C. Christian Berg, PE

February 6, 2020

Re: Lot 1 – 2434 Neills Creek Road
Lillington, NC

At your request, I have reviewed the plans proposed for new construction at this address. These plans were purchased from Frank Betz Associates and are entitled "The Foxcrofte". The architectural plans are dated 8/9/02, and the structural plans are dated 5/12/03. I reviewed the following sheets:

**TRAY CEILING DETAIL**  
 F3 1/2" = 1'-0"

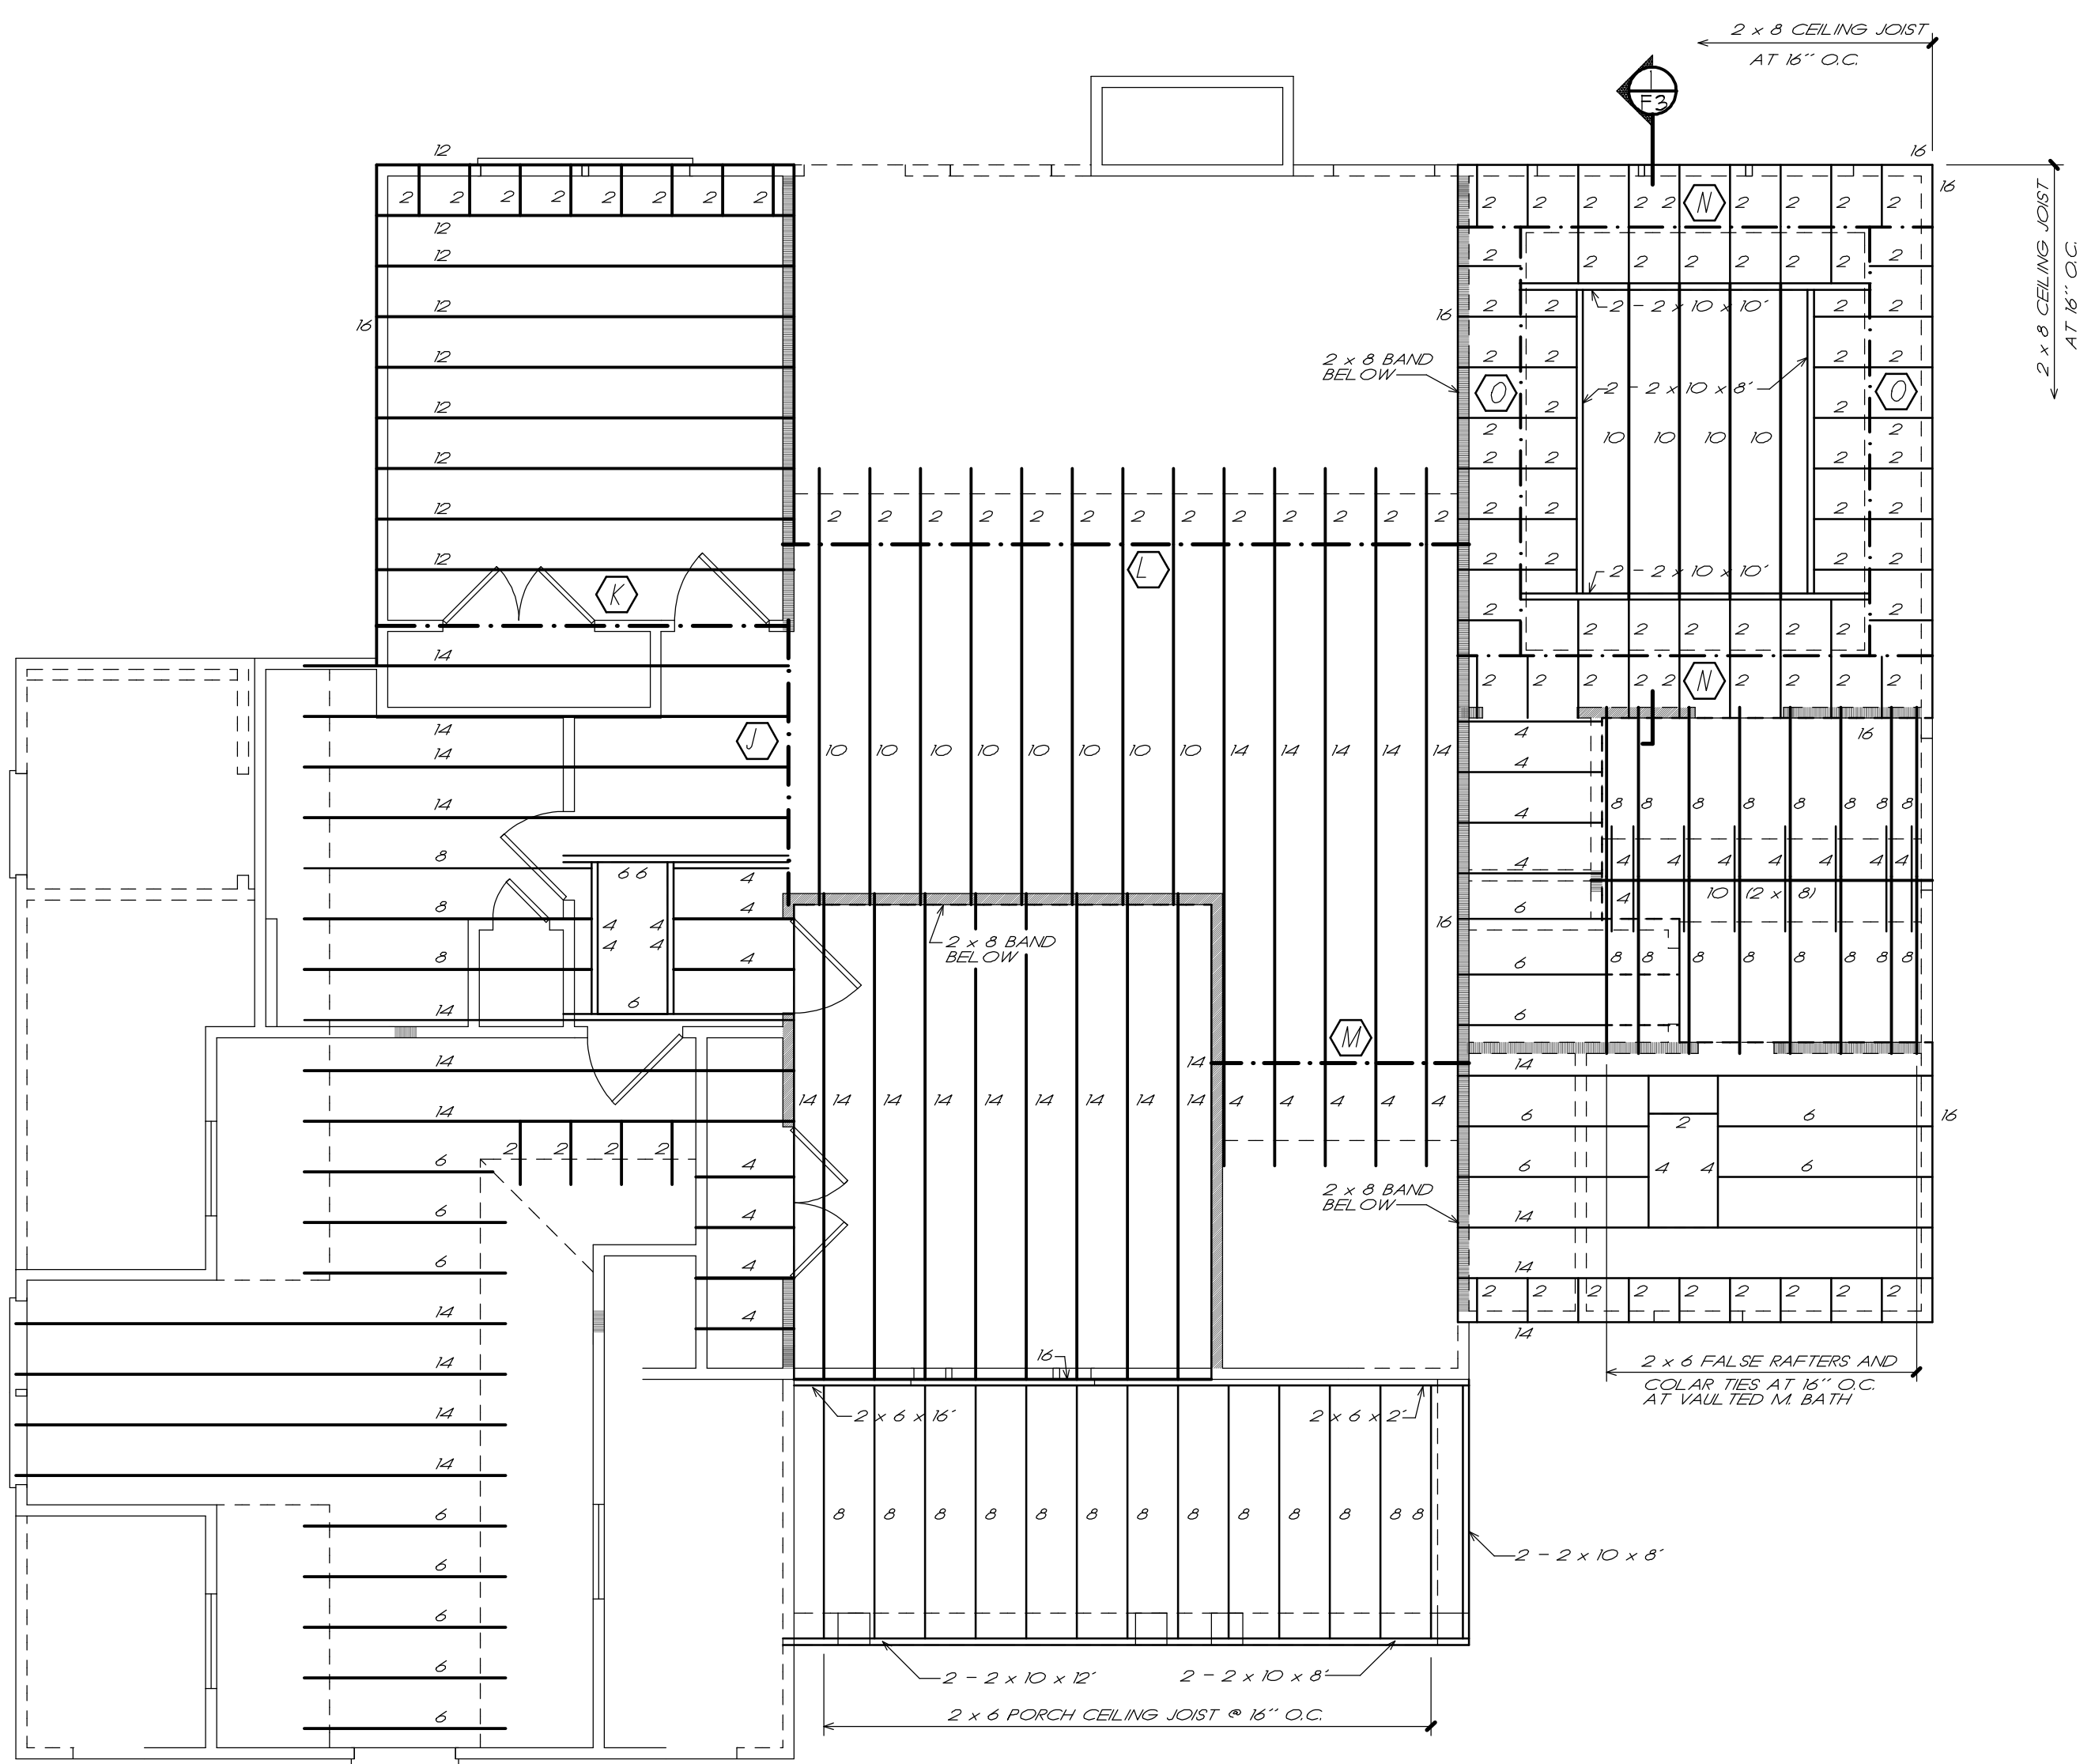
BEAM SCHEDULE	
(N)	2 - 2 x 8 x 8' BEAM FLUSH
(K)	3 - 2 x 10 x 12' BEAM FLUSH ← 3-2x12
(L)	2 - 1 3/4" x 18" x 18' LVL BEAM FLUSH ← 2-1.3/4"x16" LVL
(M)	2 - 2 x 12 x 8' BEAM FLUSH ← 2-1.3/4"x16" LVL
(O)	2 - 2 x 12 x 14' BEAM FLUSH
(P)	2 - 2 x 12 x 12' BEAM FLUSH

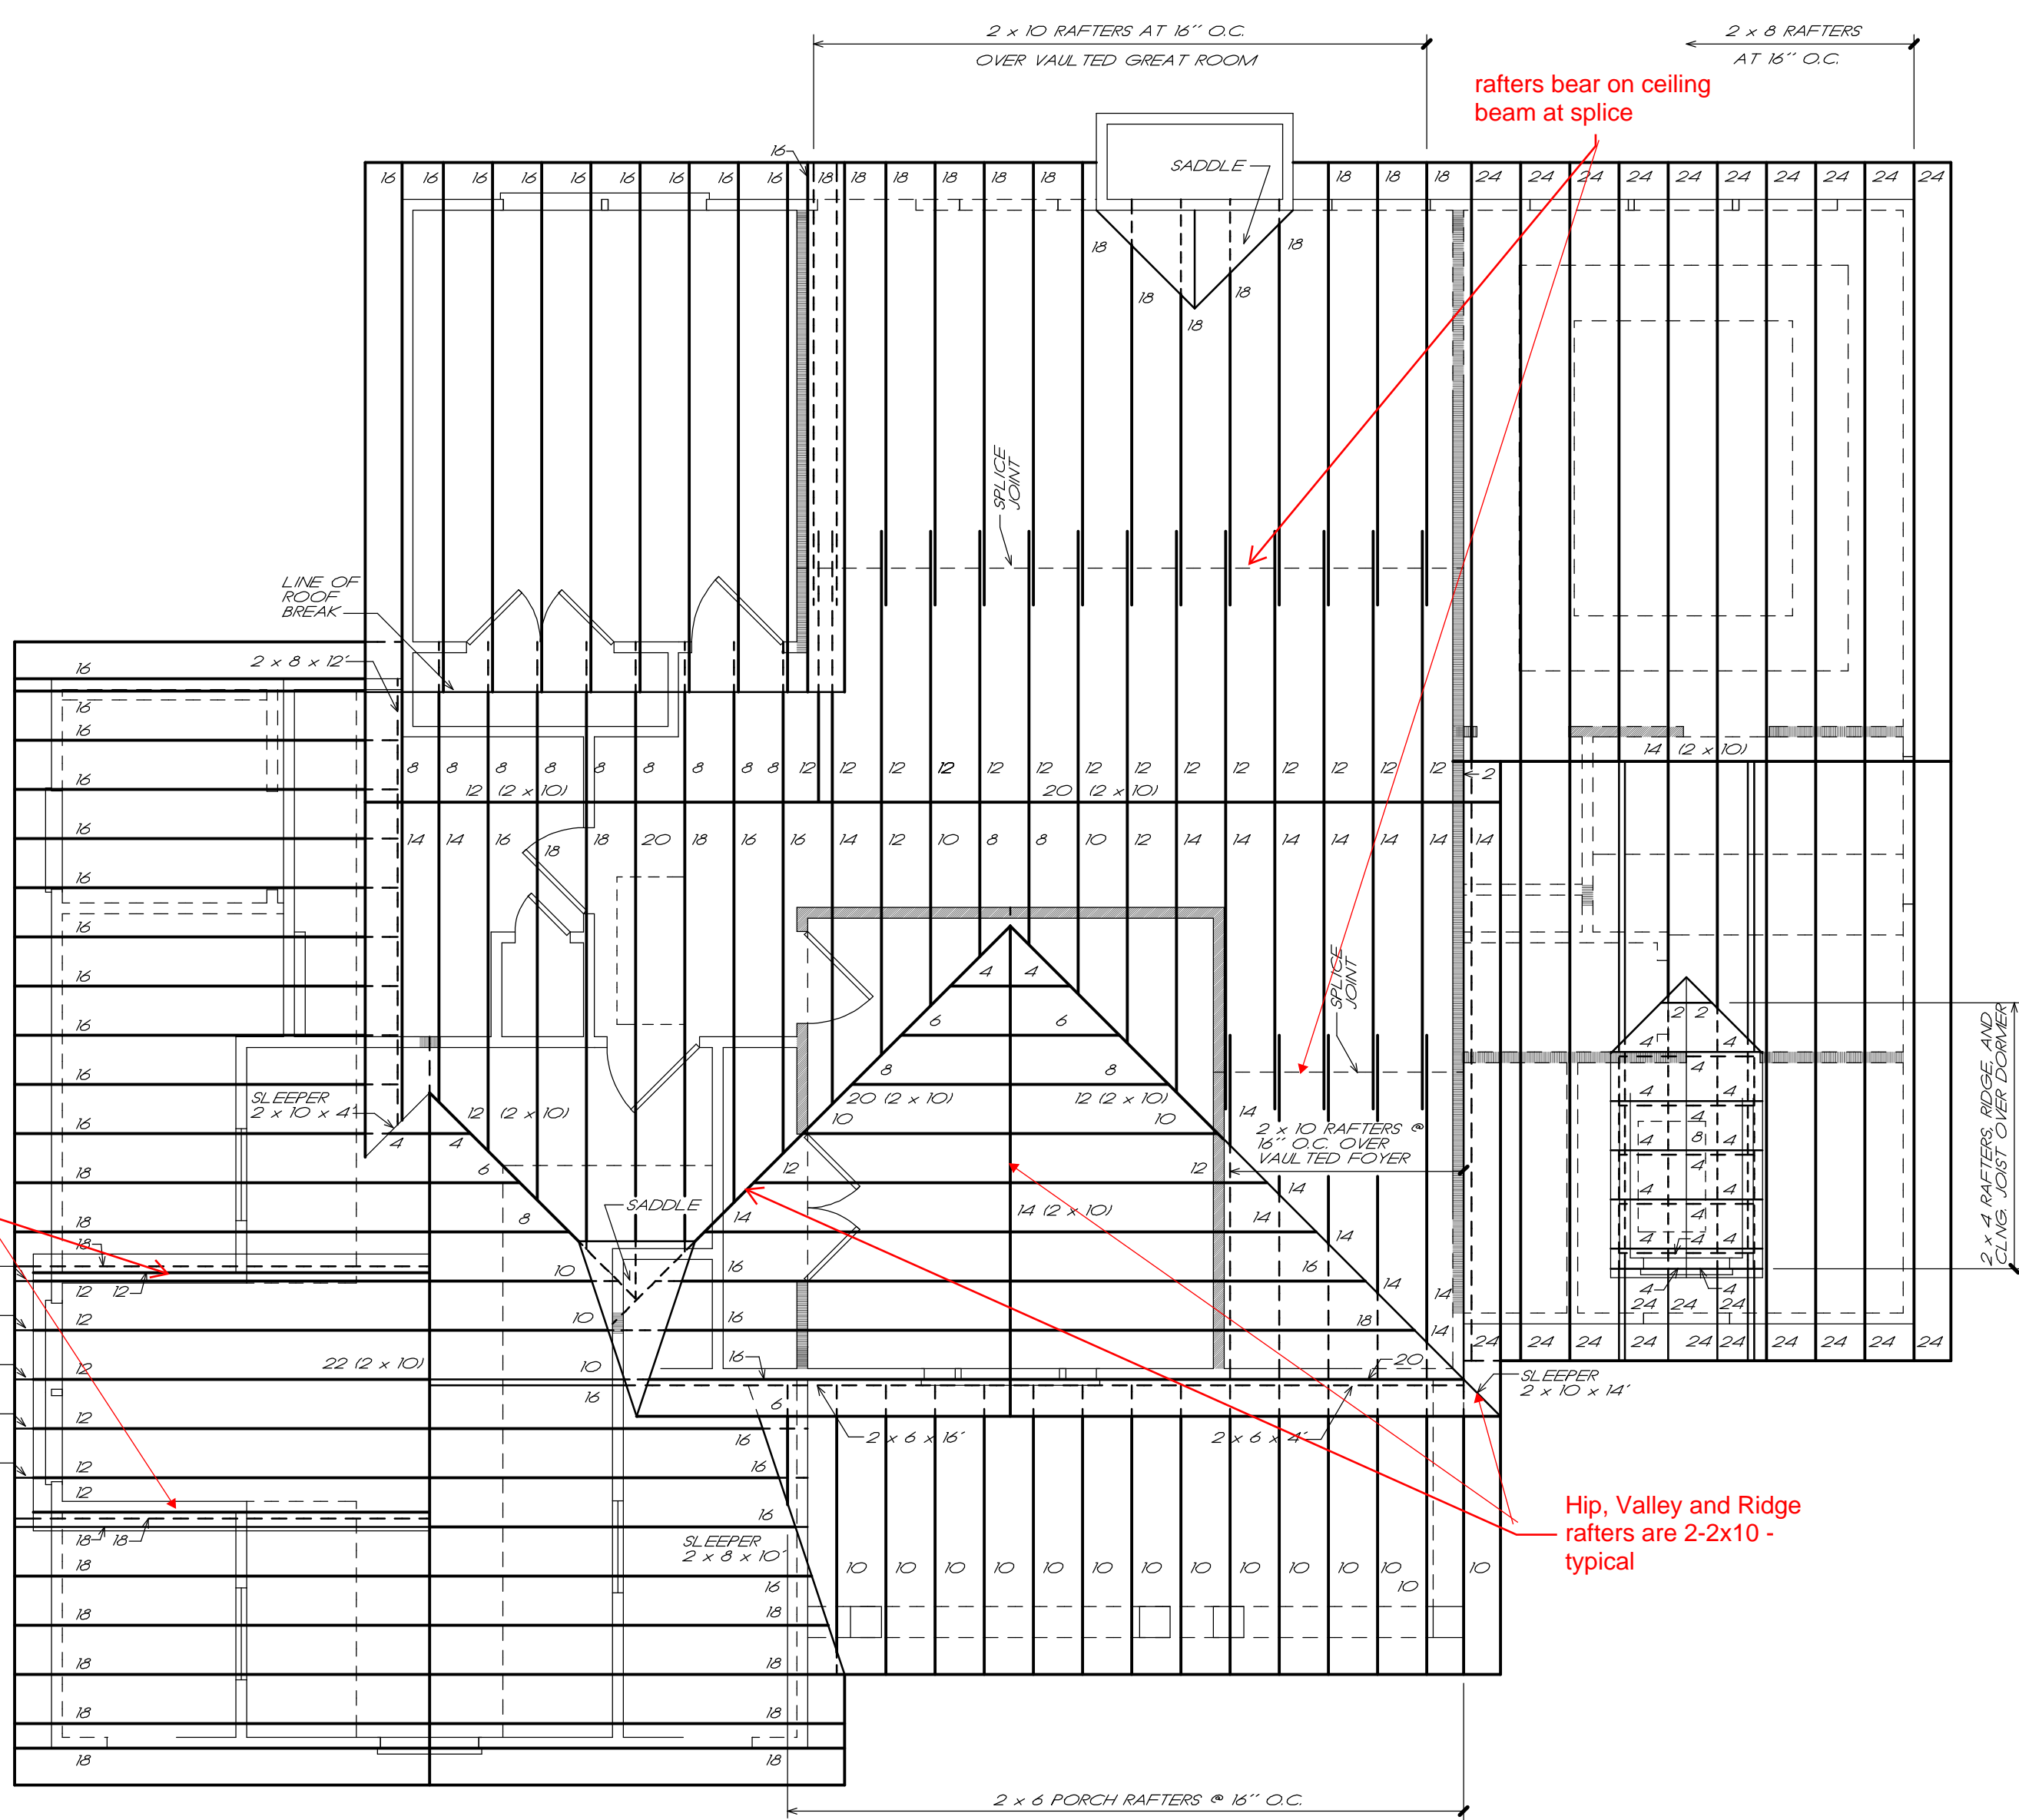
Double joist each side of dormer

Hip, Valley and Ridge rafters are 2-2x10 - typical
